Response to Planning Application

From: Arun District Council Greenspace

Application ref: AB/135/20/OUT

Location: Land at Ford Road Arundel

Parameter Plans

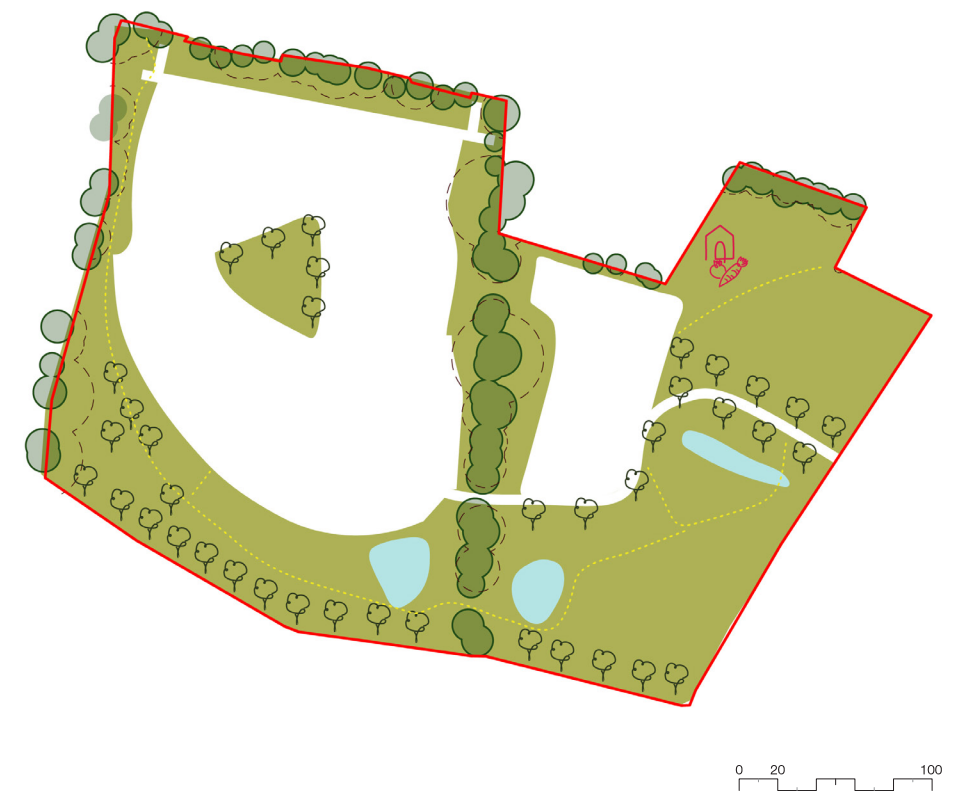
The vehicular access for the site from Ford Lane is shown to bisect the lower tree line which could have potential conflict with root protection areas and high value retained trees in this location. The layout should ensure there is no incursion into the RPA; this is especially relevant where there are trees of high public amenity, outstanding landscape, ecological and heritage value.

Illustrative Masterplan

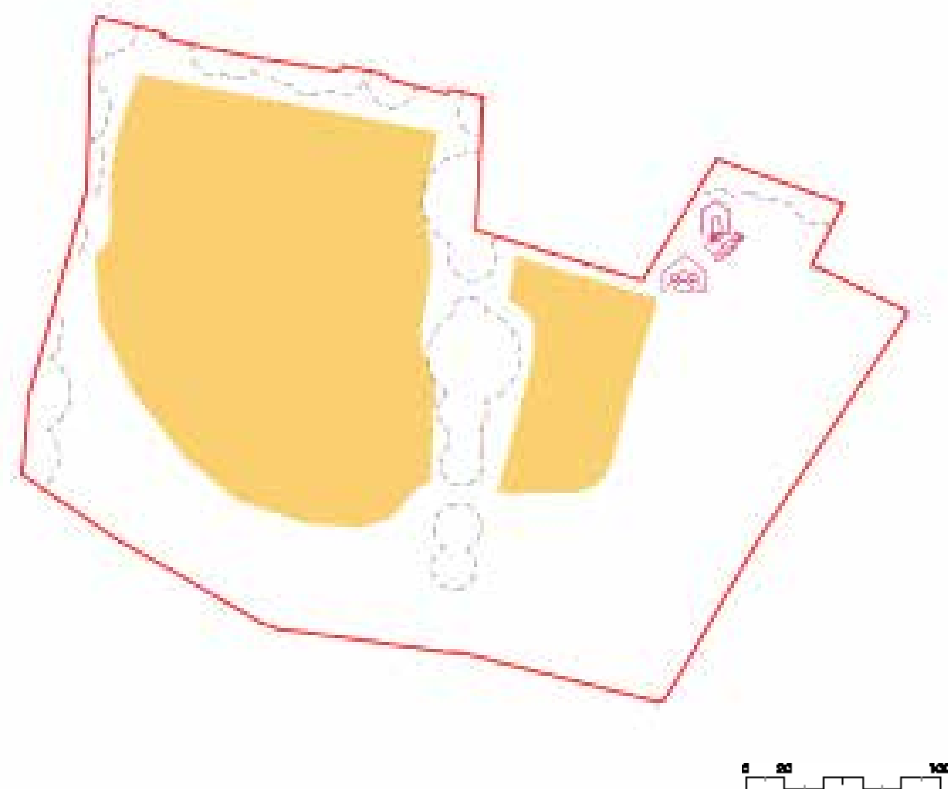
The Illustrative Masterplan Drawing No. IM003 Rev. 1 identifies that an area of land in the eastern part of the site would not be developed in order to maintain views of the Arundel skyline. It is considered that the limiting of the area of residential development, the provision of areas of green and blue infrastructure and the proposed tree planting would protect the views outwards from Arundel as well as towards Arundel to ensure the development complies with Policy LAN DM2 'The Setting of Arundel'.

The site presently medium sized pasture with some enclosure due to mature trees and hedgerow boundaries. The Illustrative Masterplan Drawing No. IM003 Rev. 1 layout has shown 90 dwellings within the proposals with areas of peripheral open space to the south and east of the proposals and an area of POS, denoted 'Central Green' at the heart of the scheme.

The Central Green area would appear to have been considered in relation to the dwelling locations with the intent of forming a village centre setting. Consideration will need to be given re the inclusion of play into this area, where a LEAP is shown and to ensure that the space afforded this green area is still sufficient to give this open character area as envisaged. The Illustrative Masterplan does not show inclusion of Local Areas of Play (LAPs) which should be provided for in the form of several on-site, unequipped natural play areas. The LAPs should include such features as landform, boulders or logs, seats and litter bins.

Considerable buffer areas have been shown to the perimeter and along tree line areas which should accommodate and protect the significant trees across this site. Consideration appears to have been given to facing dwellings onto POS areas in line with good design principles.

The indicative layout appears to show areas detailed with SuDS within the POS areas. SuDS are required to be fitting with the development and well designed to be an asset to the site, to provide interest, visually and biodiversity enhancement. Existing watercourses within the site need to be protected from change. The watercourses / ditches / culverts passing through the site and also located to the perimeter of the site will require due consideration early on in the design stage, ensuring these are incorporated, well designed and fitting within the POS areas.

Pedestrian and cycle routes within the development should be a considered design features and their meaningful connection both within and beyond the site detailed. The Masterplan identifies the pedestrian and cycling access points from Ford Road, Dalloway Road, High Ridge Close and Priory Lane and would enable the development to connect and integrate with the existing community. It is important that these comply with width and surfacing requirements to allow these to be all weather, accessible for all, particularly important in high trafficked areas. A leisure trail incorporating circular walks and activity trails has been included within the proposals.
